**WELWYN HATFIELD BOROUGH COUNCIL
EXECUTIVE DIRECTOR - PLANNING, PUBLIC PROTECTION AND GOVERNANCE**

Application No: 6/2018/0642/VAR
Location: 37 Broadwater Road Welwyn Garden City AL7 3AX
Proposal: Variation of condition 16 (approved plans) on planning permission 6/2016/2497/MAJ
Officer: Ms Louise Sahlke

Recommendation: Refused

drawing title
 PROPOSED ELEVATIONS

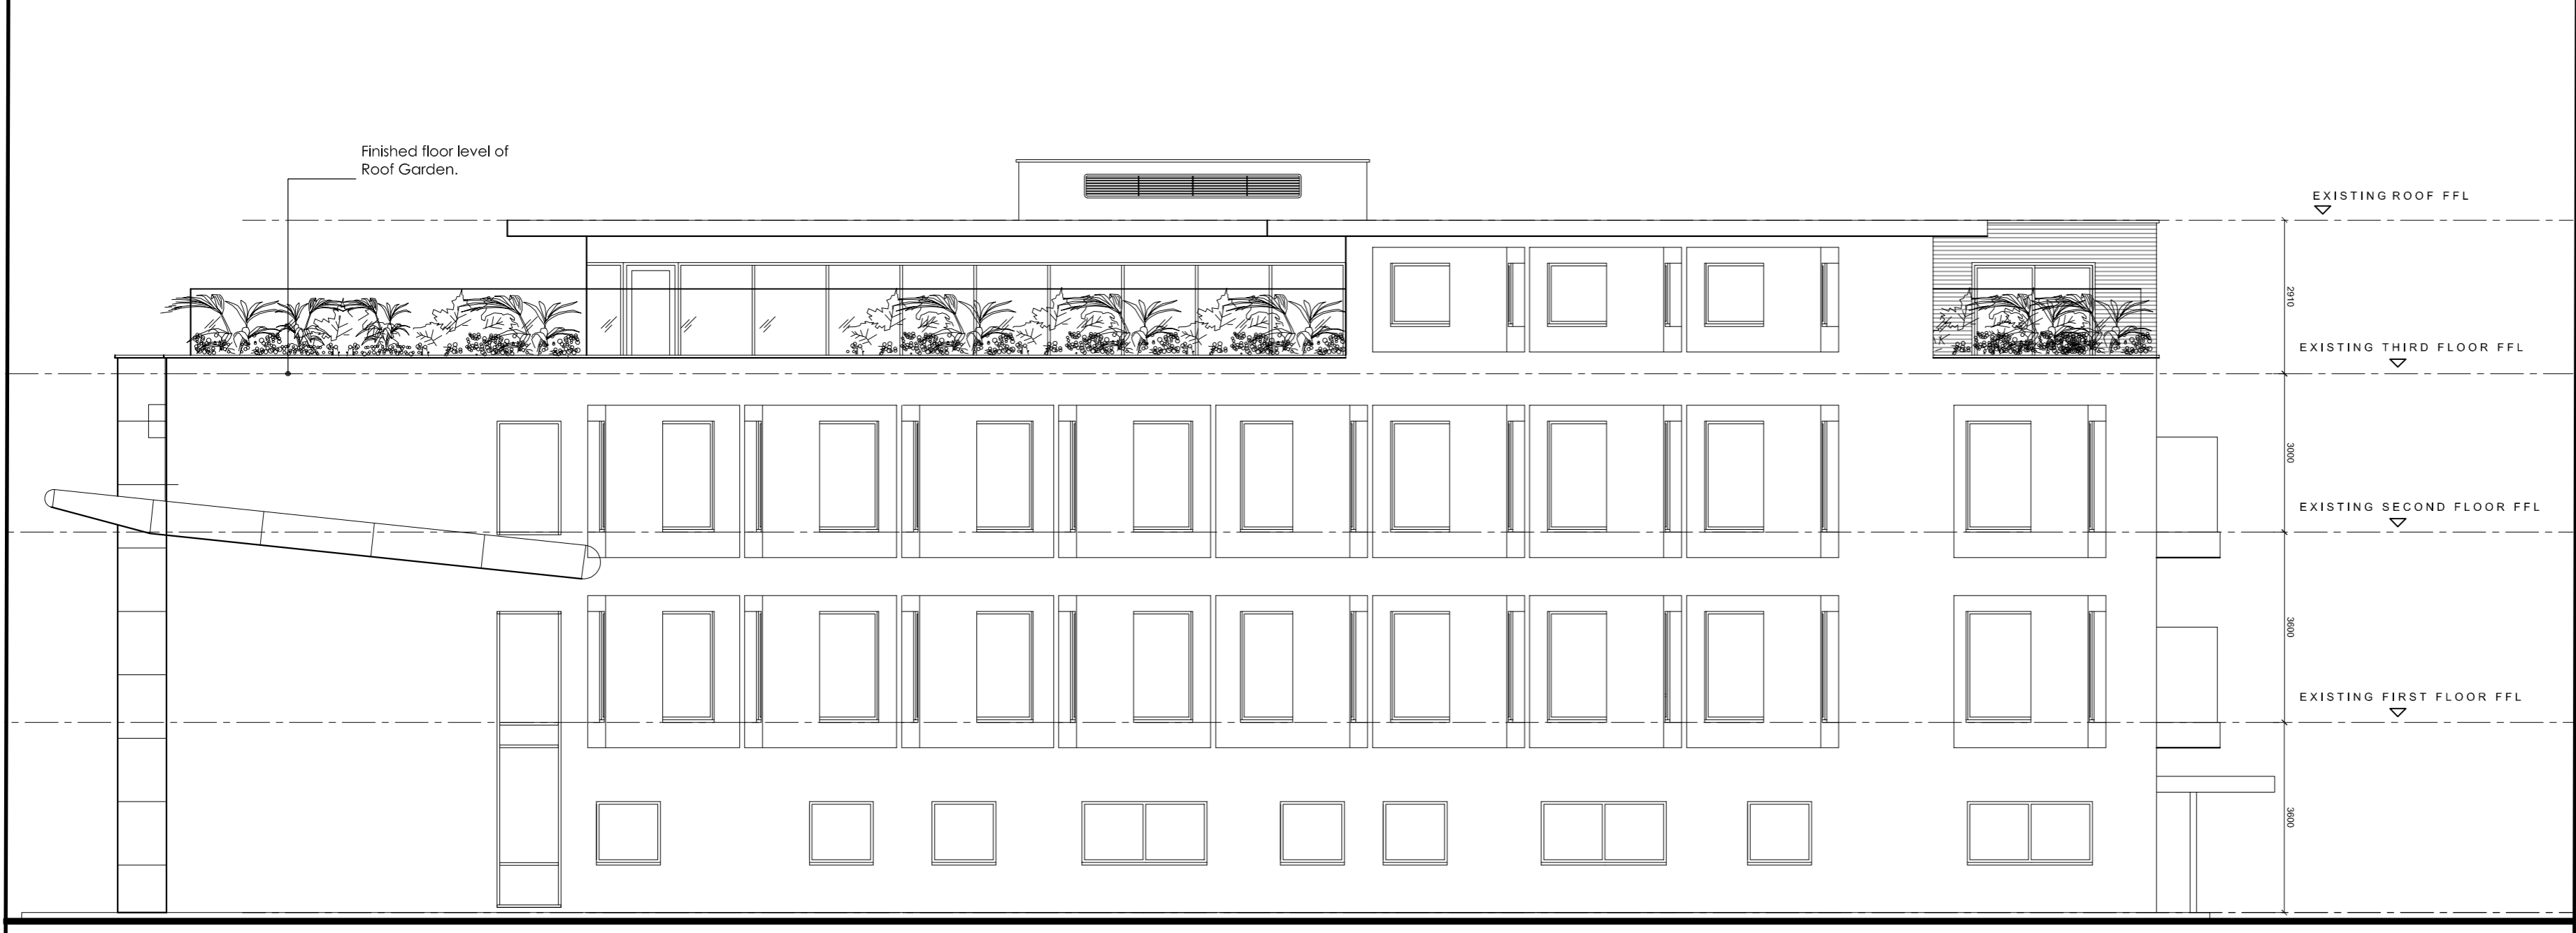
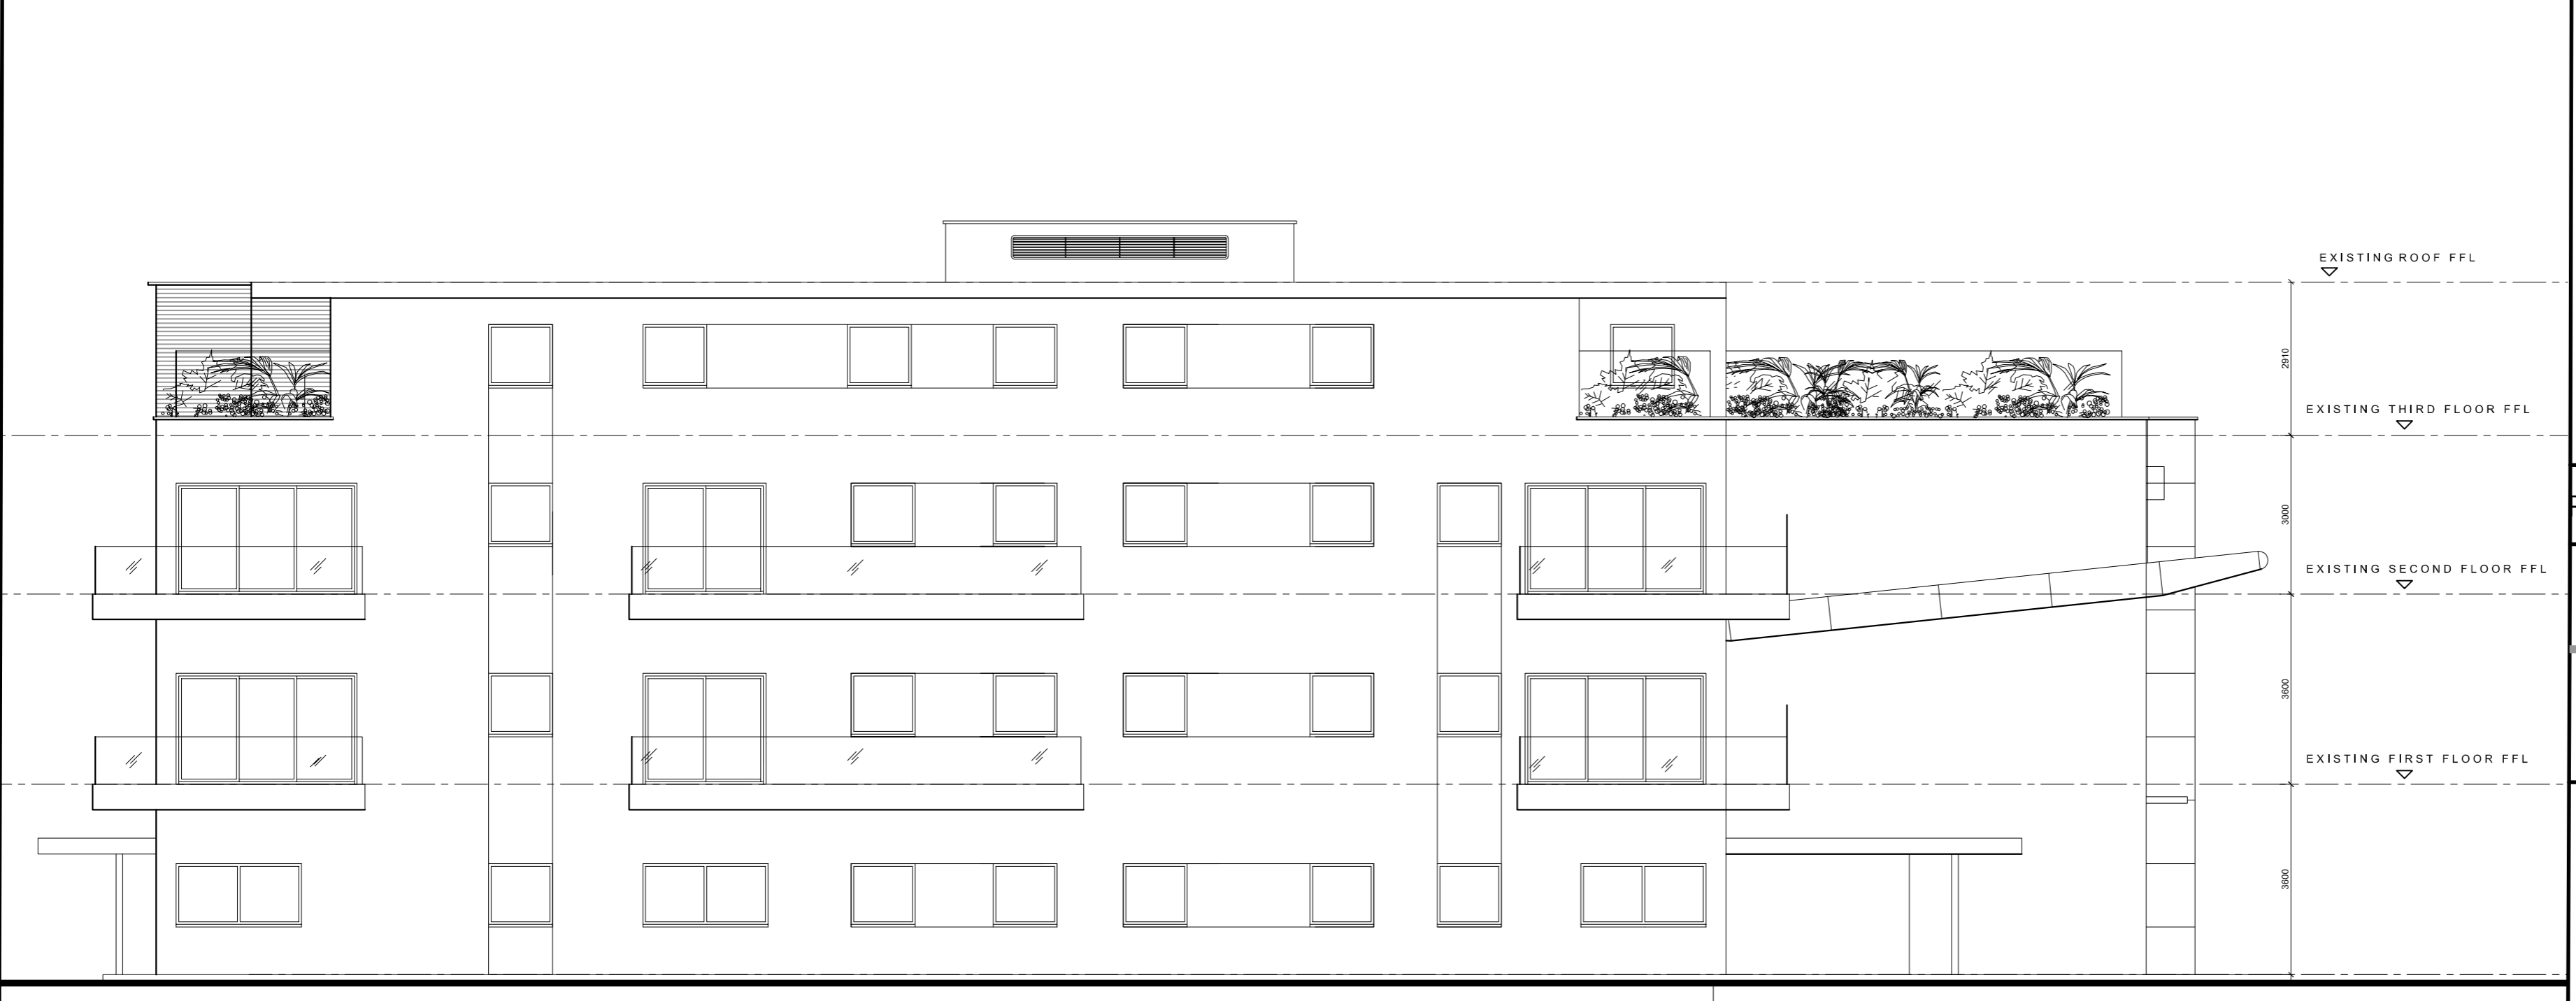
Main Issues	
Background	<p>The Case Officer has noted that there are minor amendments to the proposed elevations when compared to the approved plans. These have not been applied for under this application. However as these are demonstrated clearly on the plans, it is considered that assessment can be undertaken and further neighbour consultation is not required.</p>
Whether the site is required to meet future employment requirements and business and community needs	<p>The principle of development was discussed under planning application reference 6/2016/2497/MAJ. The loss of the site to residential use within the employment area was assessed against both Policy EMP2 of the District Plan 2005 and Policy SADM10 of the Draft Local Plan Proposed Submission 2016.</p> <p>It is not considered that there is any material change in planning policy which would impact on the principle of development. Therefore it remains that the employment use of the building has effectively ceased. Therefore the principle of development is considered acceptable in regards to the National Planning Policy Framework 2012, Policy EMP2 of the District Plan 2005 and Policy SADM10 of the Draft Local Plan Proposed Submission 2016.</p>

<p>In relation to the elevational changes to the scheme, these would not negatively alter the contextual design and built form of the proposal. The proposed elevational alterations would not significantly impact upon any of the other material considerations that were relevant under the original application. These considerations weigh substantially in favour of the scheme.</p> <p>The sedum roof was considered to soften the bulk and mass of the proposal and to match those on the opposite side of the road and to ensure that the proposal is in keeping with the key, soft landscaping ethos of the garden city. The change of the sedum roof to a single ply roof would not be highly visible from the public realm and therefore on balance its removal is considered acceptable.</p> <p>The internal alterations to the built form are considered acceptable and are not considered to impact on the bulk, size and massing of the proposal.</p> <p>The NPPG governs the use of conditions in planning and the power to impose conditions when granting planning permission is very wide. If used properly, conditions can enhance the quality of development and enable many development proposals to proceed where it would otherwise have been necessary to refuse planning permission. The objectives of planning, however, are best served when that power is exercised in such a way that conditions are seen to be fair, reasonable and practicable. Conditions should only be imposed where they are necessary and reasonable, as well as enforceable, precise and relevant both to planning and to the development to be permitted. In relation to this proposal, a successful application to amend conditions results in the issue of what is in effect a new planning permission, but does not cancel the old permission.</p> <p>It is reasonable therefore that the current planning application should be subject to the same conditions as the previous planning application, 6/2016/2497/MAJ whereby conditions were applied, as they remain in accordance with the tests set out in paragraph 206 of the NPPF.</p> <p>It is recommended that suitably worded conditions are attached to ensure compliance with the approved details. Where conditions have been agreed, their wording has been amended accordingly.</p> <p>Therefore subject to conditions, the proposal is considered acceptable in regards to the National Planning Policy Framework 2012, Policies D1, D2 and D8 of the District Plan 2005 and Policies SADM SP9, SP10, SADM11 and SADM12 of the Draft Local Plan Proposed Submission 2016.</p>
